**Re: BP#2016-01146 767 Congress Street**

I have done a site visit to 767 Congress Street, and there is no obstructions to the fire department connection for the proposed fence location.

PLOT PLAN

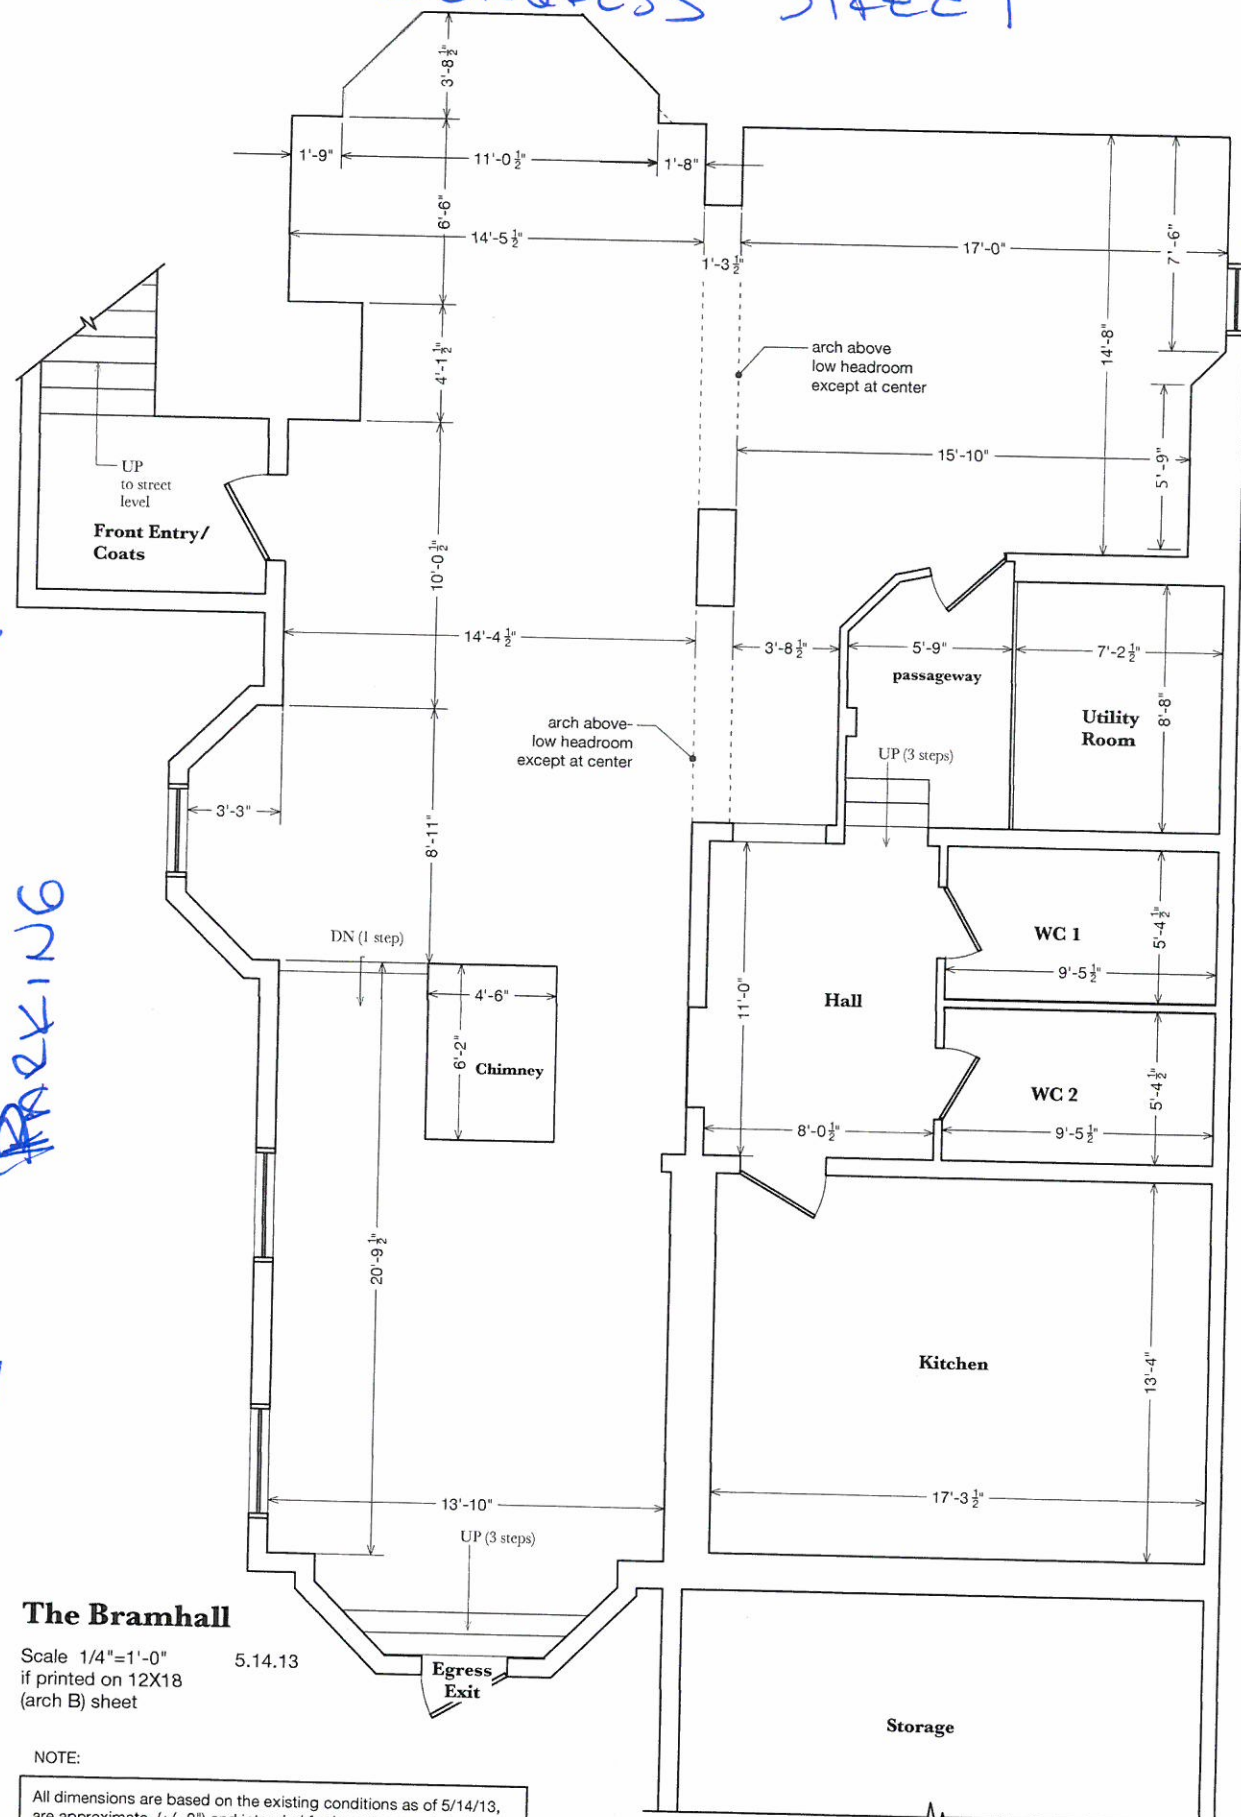
Regarding the above permit, here is how my code reads:

**912.3 Access.** Immediate access to fire department connections shall be maintained at all times and without obstruction by fences, bushes, trees, walls or any other fixed or moveable object. Access to fire department connections shall be *approved* by the fire chief. [F]

**Exception:** Fences, where provided with an access gate equipped with a sign complying with the legend requirements of [Section 912.4](#) and a means of emergency operation. The gate and the means of emergency operation shall be *approved* by the fire chief and maintained operational at all times.

**912.4 Signs.** A metal sign with raised letters at least 1 inch (25 mm) in size shall be mounted on all fire department connections serving automatic sprinklers, standpipes or fire pump connections. Such signs shall read: AUTOMATIC SPRINKLERS or STANDPIPES or TEST CONNECTION or a combination thereof as applicable. Where the fire department connection does not serve the entire building, a sign shall be provided indicating the portions of the building served. [F]

I think I need approval from you to allow this fence. Also, are these signs typically in place all ready or should I put this in as a condition for approval.
